**ExQ2: 03 August 2021****Responses due by Deadline 7: 03 September 2021**

<b>ExQ2</b>	<b>Question to:</b>	<b>Question:</b>
<b>CC.2 Climate change and resilience</b>		
CC.2.0	The Applicant	<p><b>General Climate Change and Policy Issues</b></p> <p>On 20 July 2021, the Environment Agency published updates to the climate change allowances for flood risk assessments. The changes updated peak river flow allowances to reflect the UK Climate Projections (UKCP18) and modelling for rainfall. Please indicate whether there are any differences to the Sizewell C Project assessment resulting from the new projections?</p>
CC.2.1	The Applicant, EA	<p><b>General Climate Change and Policy Issues</b></p> <p>In response to ExQ1 CC.1.17 [REP2-100], the Applicant states that: <i>"UKCP18 RCP8.5 95th percentile climate change allowance has been adopted within the assessment of flood risk, in respect of the main platform and sea defence designs, in accordance with the guidance set out in the Position Statement on the Use of UK Climate Projections 2018 (UKCP18) by GB Nuclear Industry, March 2019, which was the latest guidance at the time of the assessment"</i>. Please confirm that that still remains the la

Figure 3.13a
Fen meadow compensation potential for Pakenham Fen north site

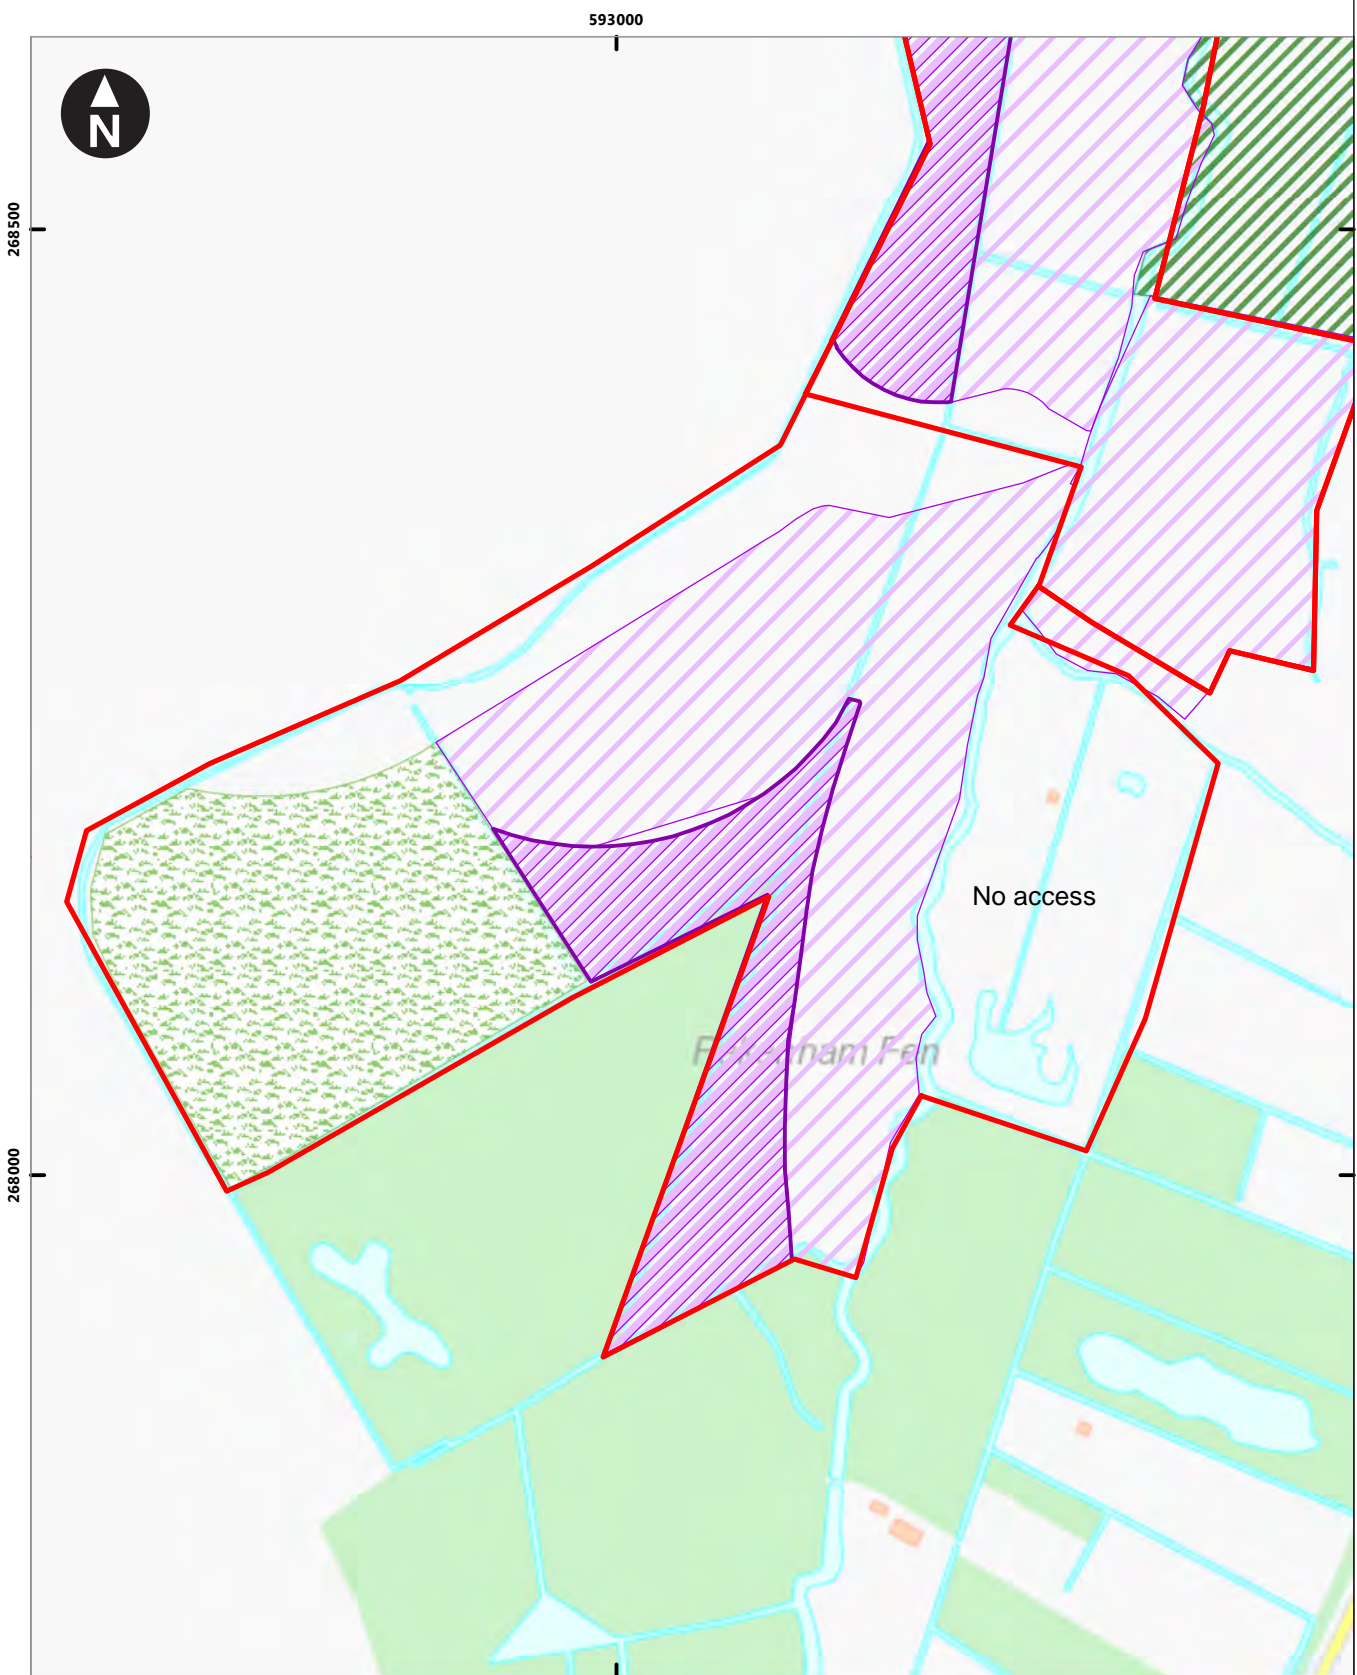
<b>ExQ2</b>	<b>Question to:</b>	<b>Question:</b>
		<p>(iii) Please explain in full the need to acquire these particular plots for the proposed development.</p> <p>(iv) The Applicant's DL3 response [REP3-049] in relation to the feasibility of re-creating fen meadow at Pakenham refers to feasibility assessment work that began in March 2021 and requires 12 months of hydrological data collection. Please justify the acquisition of this land for the purpose stated in the absence of that data and the conclusion of the feasibility work.</p> <p>(v) Please confirm the area of fen meadow that would be lost as a result of the proposed development and provide full justification for the extent of the land sought to be acquired.</p> <p>(vii) The Applicant's DL3 response [REP3-049] indicates that it is not expected that all the area within the identified Pakenham site boundary will become meadow, and that the precise area of fen meadow that could be created is uncertain and subject to the outcome of ongoing studies. Please explain further why a reduced area of land would not suffice? Given the acknowledged uncertainty and the absence of relevant data, how can the compulsory acquisition proposals be regarded as necessary and reasonable and how can the extent of the land-take be regarded as proportionate?</p> <p>(viii) The Applicant's DL3 response [REP3-049] indicates that relevant hydrological data collection has not been completed. Please respond to the concerns raised in relation to the prospect of the scheme having an adverse impact upon the use of the surrounding farmland, and the local Watermill. Please explain how Requirement 14A of the draft DCO would ensure that the potential impact upon Pakenham Water Mill and other neighbouring landowners would be satisfactorily controlled or are any additional controls required?</p> <p>(ix) The Applicant's DL3 response [REP3-049] indicates it is seeking to understand the impact of these proposals on landowners and to respond to their queries relating to the continued use of the land following establishment of the proposed fen meadow. Please provide an update in relation to that engagement.</p> <p>(x) What regard has been had to the livelihood and wellbeing of the farmer of the land and the implications for the cattle and arable enterprises and the agricultural operation as a whole when assessing the private loss to those who would be affected by the proposed compulsory acquisition?</p> <p>(xi) Please explain the consideration given to the human rights of these particular landowners and tenant.</p>
